Planning Application WA/20/26/PL

Nestled c/o Batcheller Monkhouse, Stretton House, Pulborough

Land South of The Black Horse Pub, Binsted Lane

1. I am Mr Clive Smith, owner and landlord of the Black Horse public house, Binsted. Please accept this **objection** to application WA/20/26/PL which seeks retrospective planning permission for a glamping facility on land immediately to the south of the public house.

Drawing Title: PROPOSED ARRANGEMENT
Drawing Number: 148_02
Date: February 2025
Scale: 1:500 / 1:100 @A1

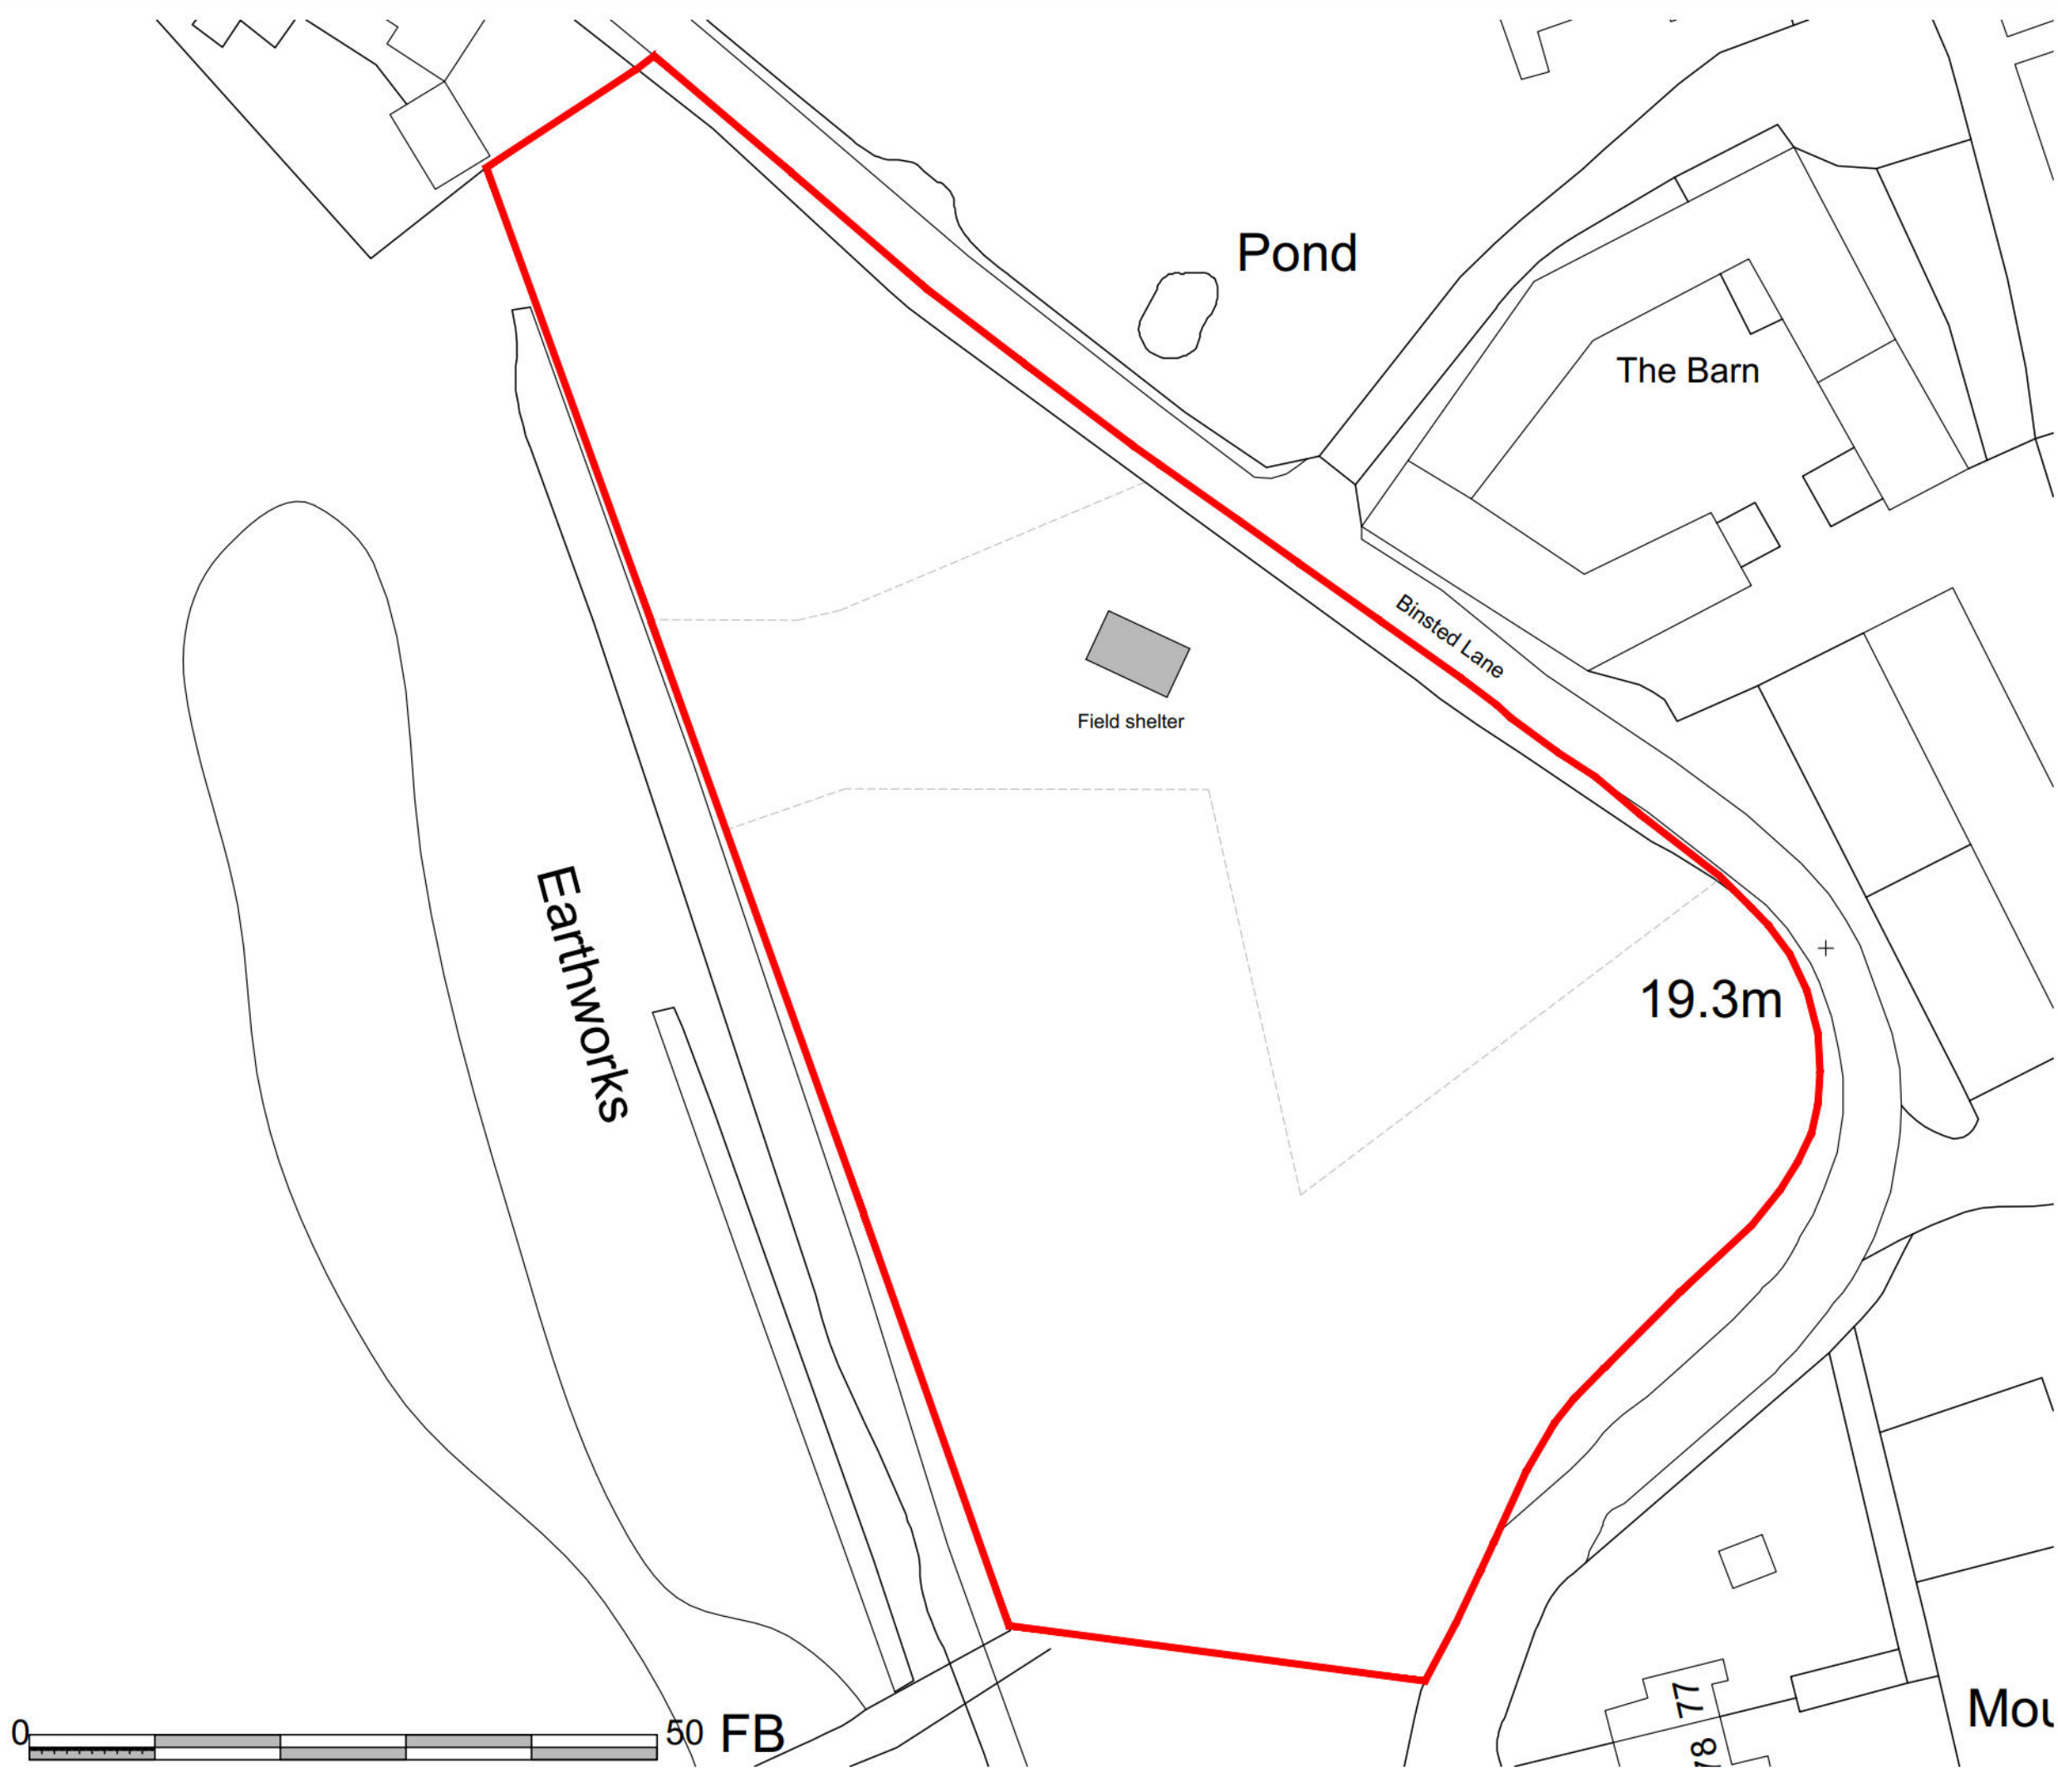
16. The internal footprint of each of the 6 units is larger. All units now have two bedrooms, rather than a mix of sizes. The base of each unit is fully enclosed. This creates a much more solid and building-like appearance, entirely unlike the 'lightweight' structure previously found acceptable. Each unit also has additional outdoor facilities, alongside a relocated hot tub. These include an outdoor cinema area with a 100" screen (according to the applicant's promotional material) and a wood-fired sauna building with a wood store and prominent chimney. Opaque wooden fencing screens each unit and creates a self-contained 'compound'. This reduces openness and affects views from adjacent property and from Binsted Lane.

17. The introduction of 1.8m high chestnut lathe fences and gates around every plot, and around the outdoor saunas, changes the character of the scheme. The units no longer sit within an open landscape setting. Instead, the fencing creates an 'urban grain' of series of enclosed, private spaces within what was intended to be retained as an open meadow.
18. Grass footpaths have been replaced with substantial gravelled tracks. A shipping container has been installed for storage and surrounded with (currently ineffective) timber screening. The LPG fuel tank is now an intrusive above-ground structure and surrounded by a solid concrete and timber security fence, as shown in the photograph below.

21. I should also point out that the glamping unit closest to the Black Horse has been incorrectly located approximately 5m closer to my boundary than is shown in either the original application or in the new proposal. The council should check this with the applicant and if necessary seek a revised plan to avoid what would otherwise be a continuing breach of planning control even if the new application were to be approved.
